RESPONSE TO SUBMISSIONS: WENTWORTHVILLE NORTHSIDE WEST CLINIC EXTENSION

23-27 LYTTON STREET, WENTWORTHVILLE
LOT 1 DP787784

RESPONSE TO SUBMISSIONS REPORT

SSD-17899480

1 DA - East Elevation - Lytton St View  
Scale: 1 : 100

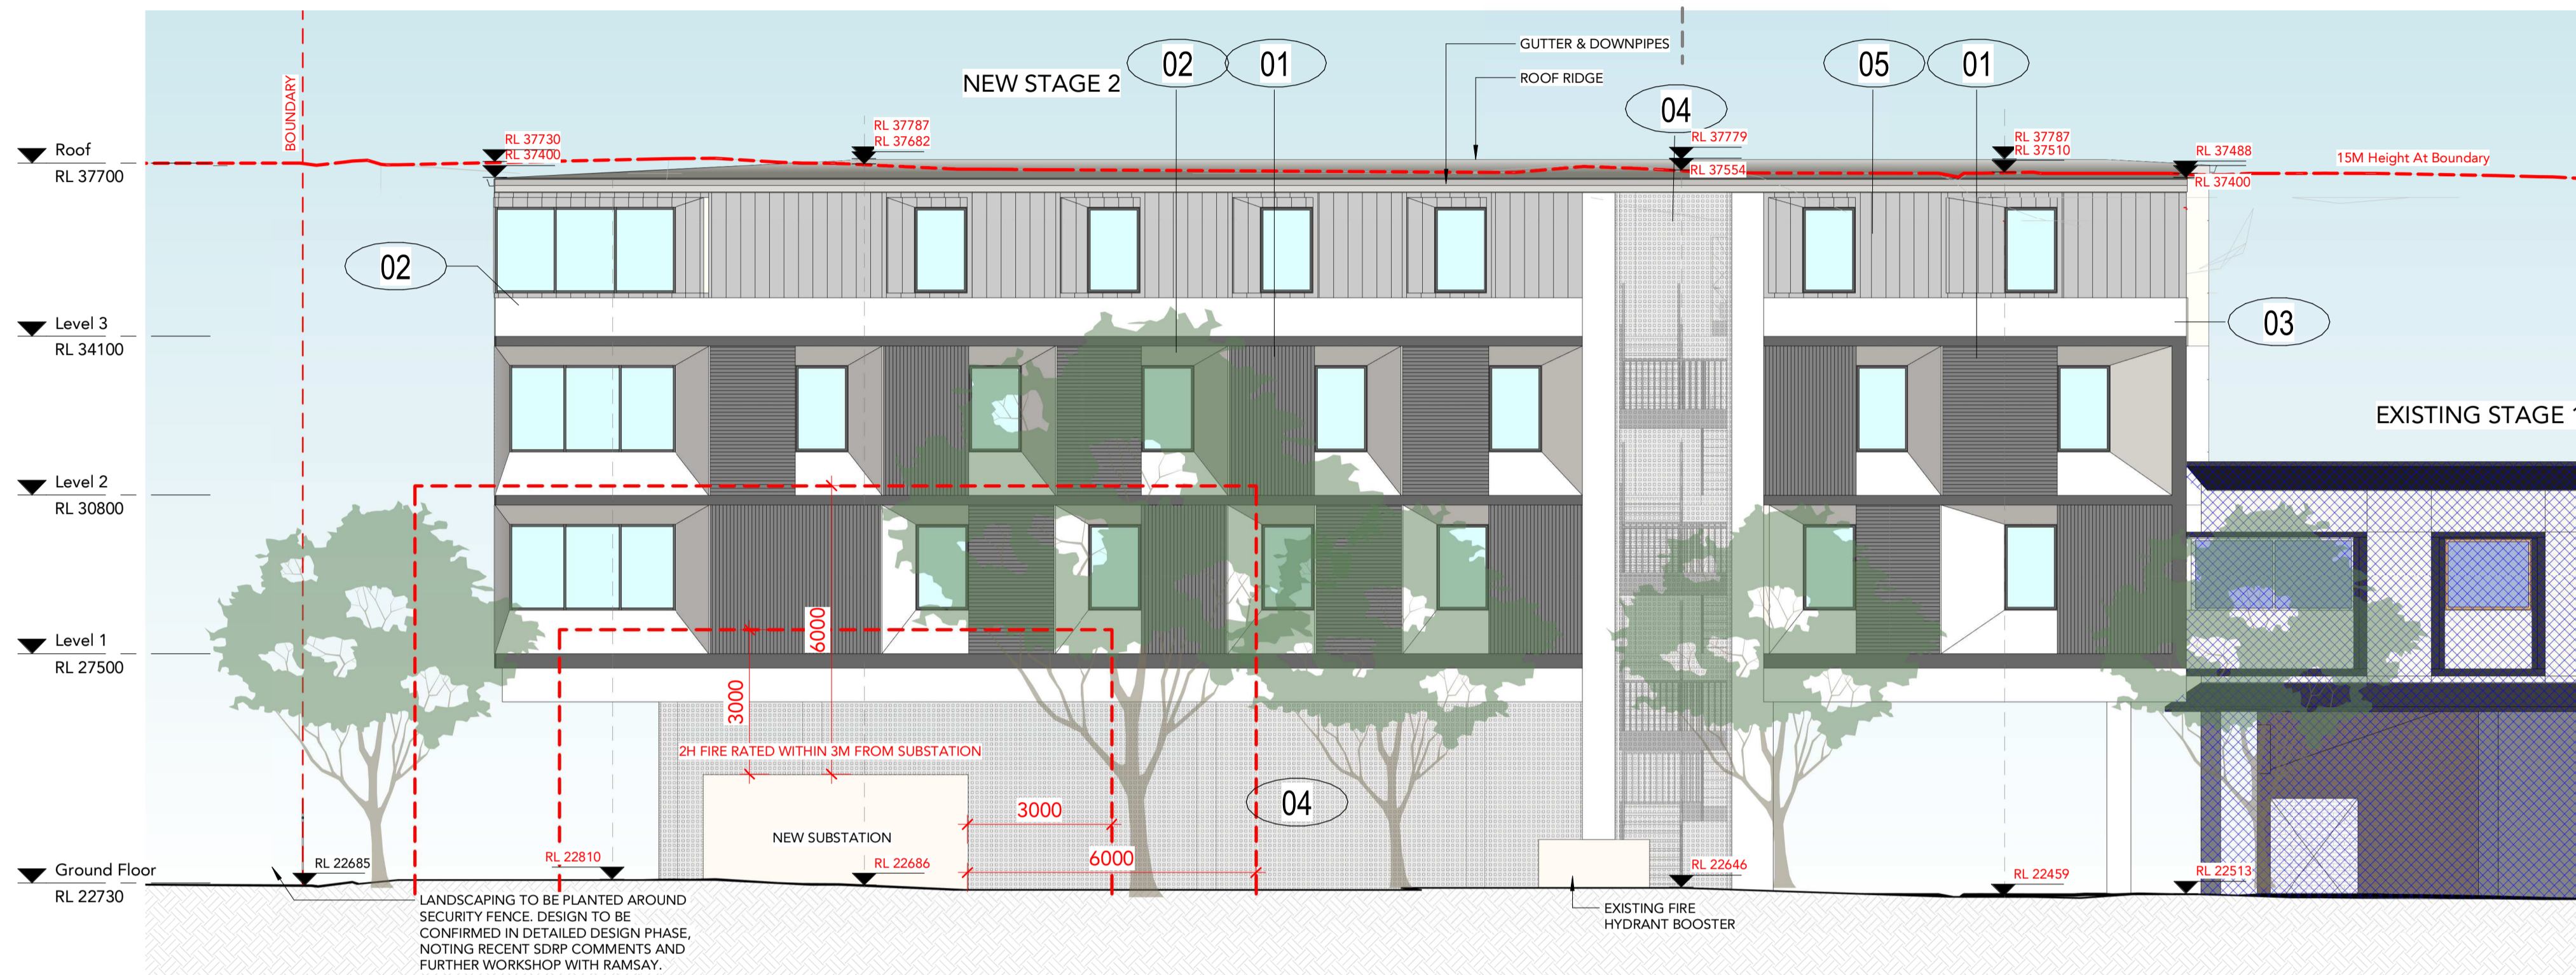
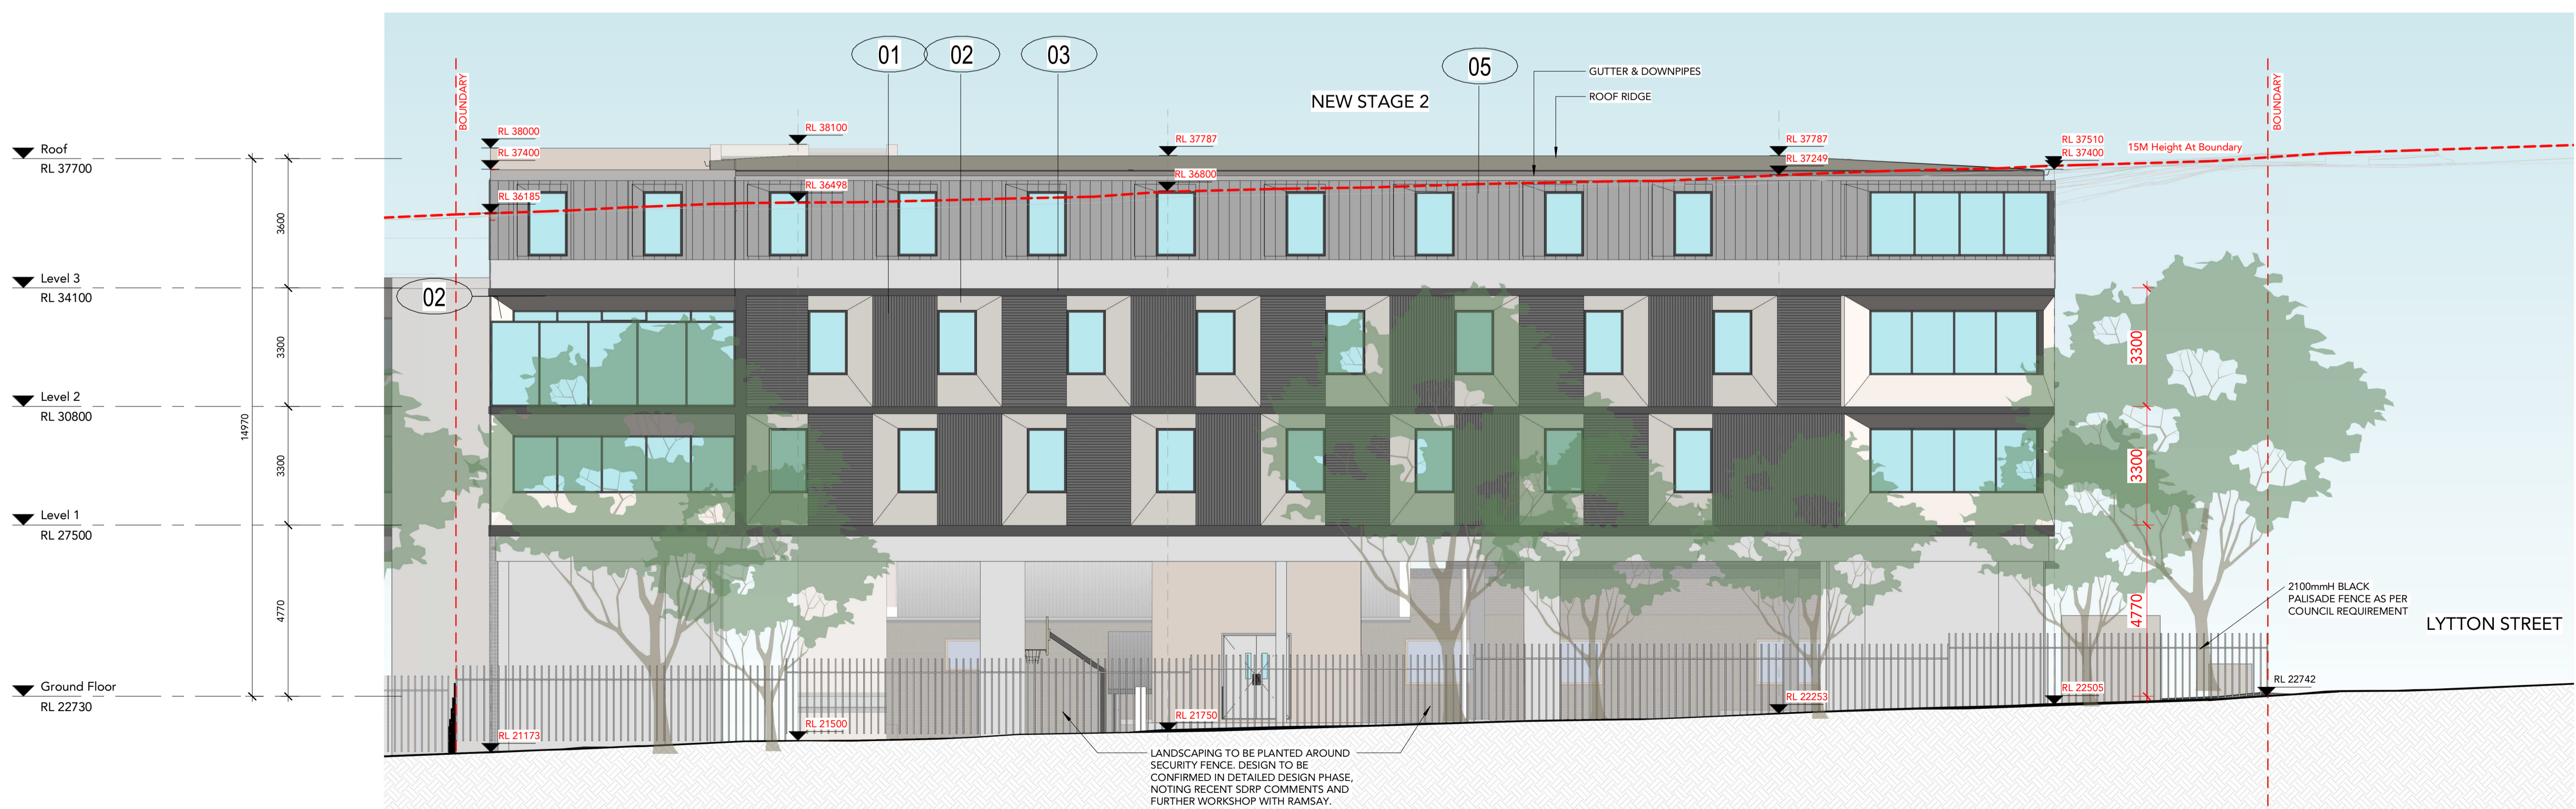
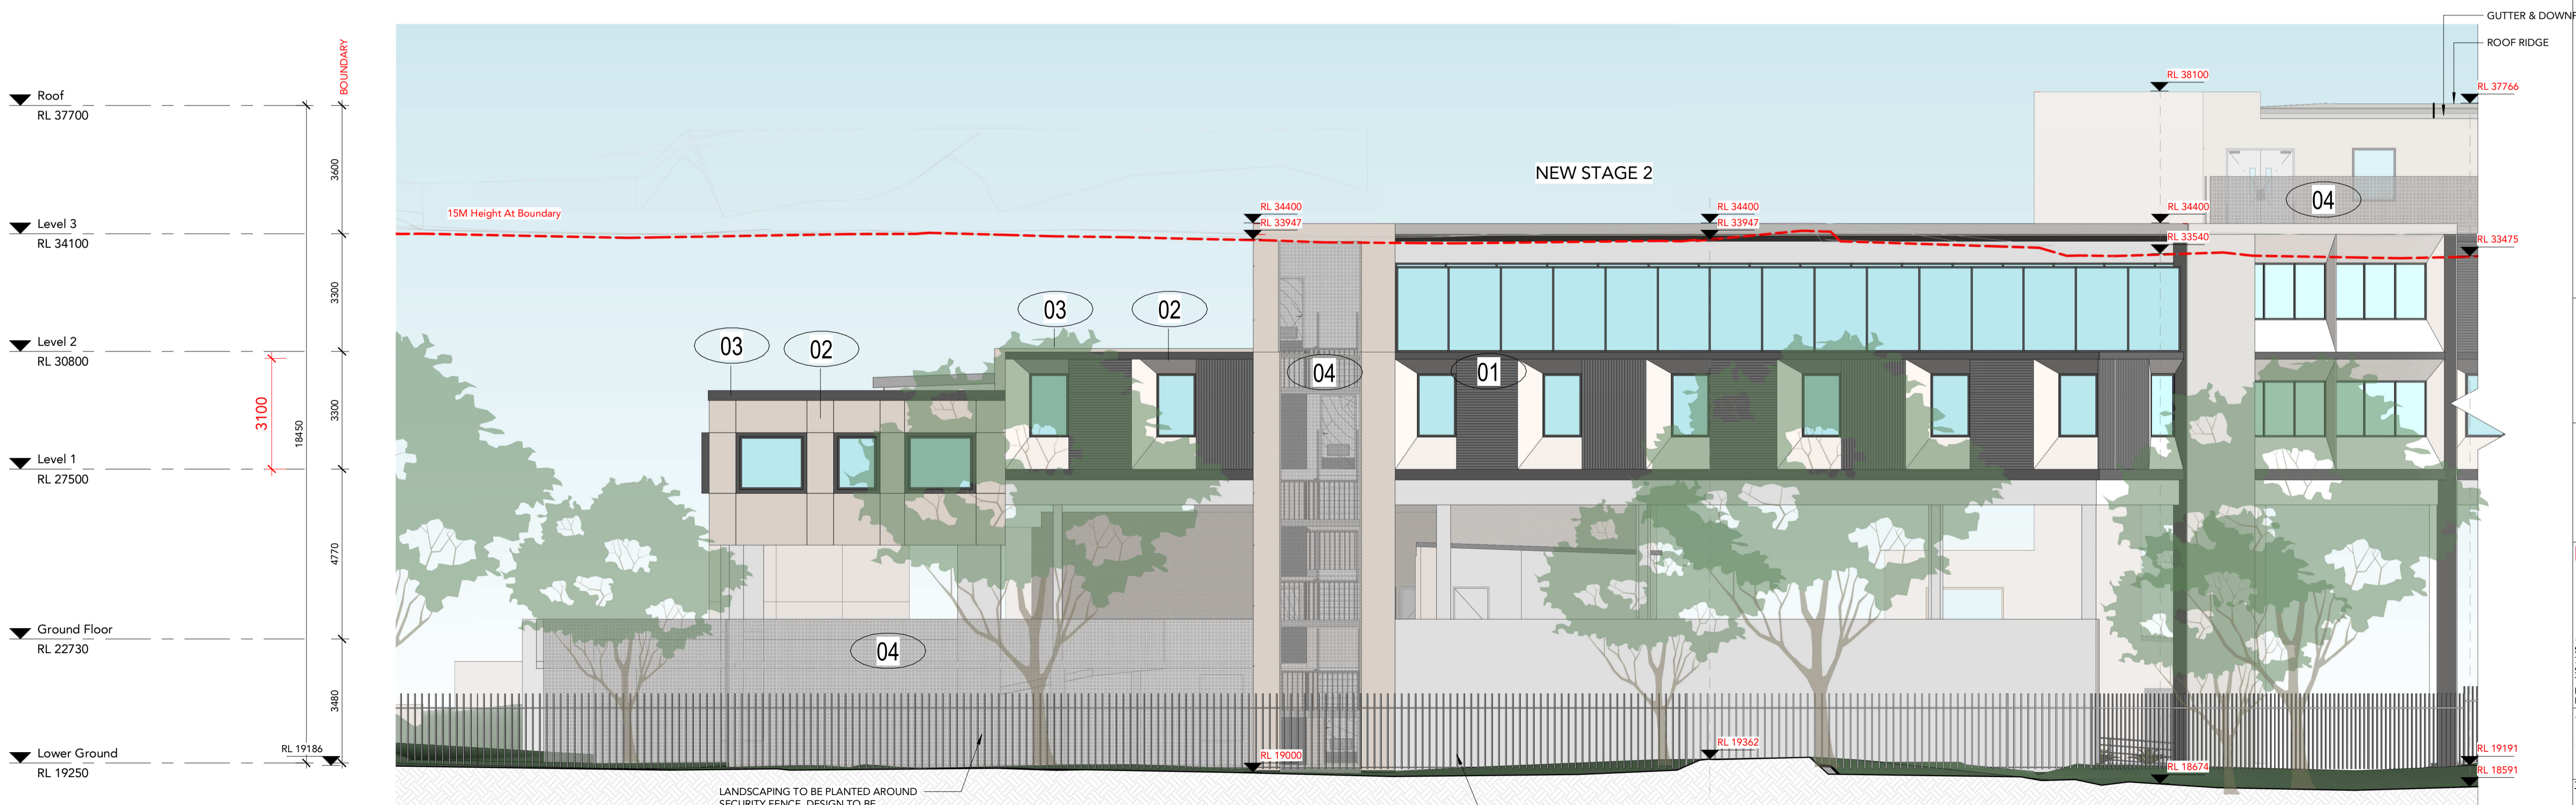
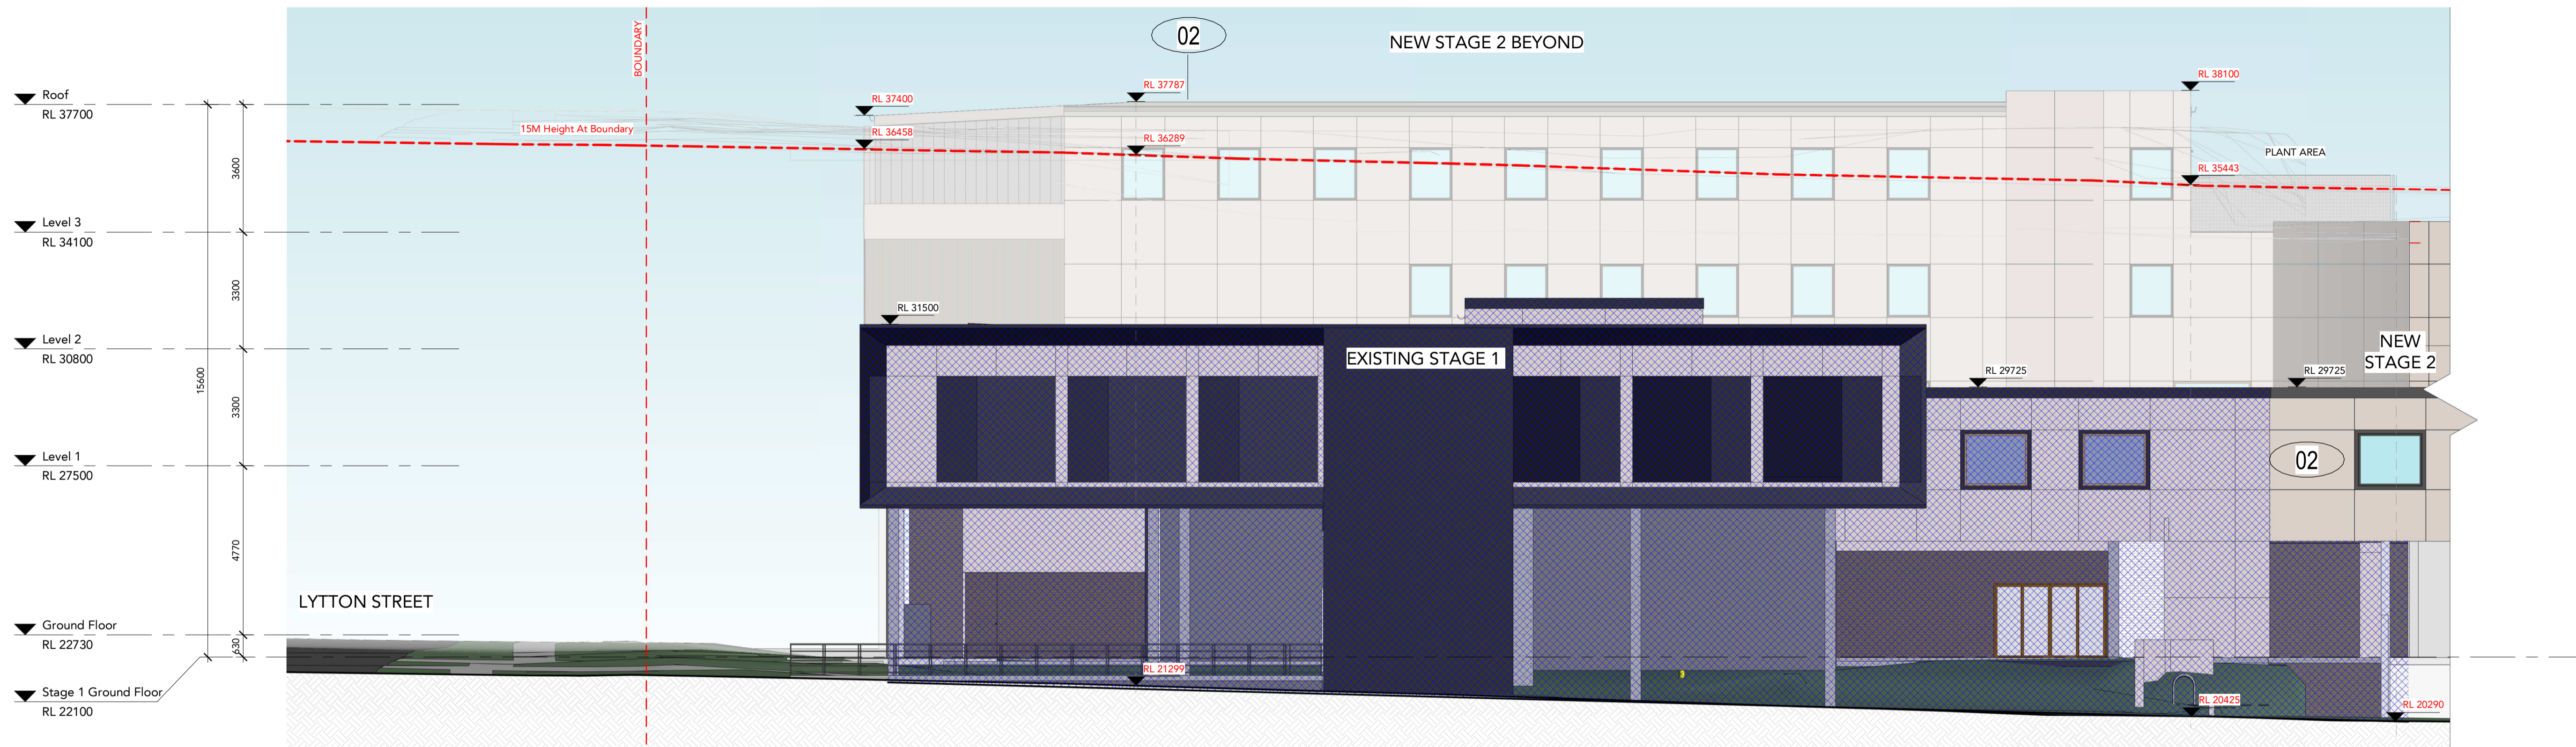
<ul style="list-style-type: none"> the external façade alignment is inconsistent with Stage 1 and does not appear to be seamless. 	<p>As demonstrated in the Elevations and renders within the Architectural Plans, the building elevations have been revised to provide a consistent façade with the existing Stage 1 building in order to keep a similar look and feel across the development.</p>
		Provide consideration of opening the western boundary ground level carpark to the landscaped areas through the removal of the screening.	<p>It is noted that screening is required along the western boundary of the carpark to maintain security and prevent access from the carpark through to the rear of the facility and vice versa.</p>
		Provide section plans of the west block.	<p>A section of the western building is provided in DA3001 within the Architectural Plans as Section D-D.</p>
		Provide natural ground RLs on all section plans below each maximum height to enable appropriate calculation of the overall exceedances.	<p>Natural ground RLs have been added to all section plans indicating the revised building height.</p>

<ul style="list-style-type: none"> include detail of the screen to the undercroft within elevations as detailed within the architecture design statement. 	Screening of the undercroft area have been demonstrated on the Elevations within the Architectural Plans.
		Redesign the lower ground car parking to ensure that the swept paths are free from obstructions.	Swept paths on the lower ground car park have been illustrated in the Architectural Plans.
		Provide details of wayfinding signage to ensure pedestrian access to the building is clear and easy to identify.	Three pylon signs will be provided along Lytton Street to indicate pedestrian access point to the building. Details of the proposed signage are provided in the Architectural Plans. An assessment against the relevant provisions under Chapter 3 of the <i>State Environmental Planning Policy (Industry and Employment) 2021</i> (Industry and Employment SEPP) is provided in Section 3.1.1 .
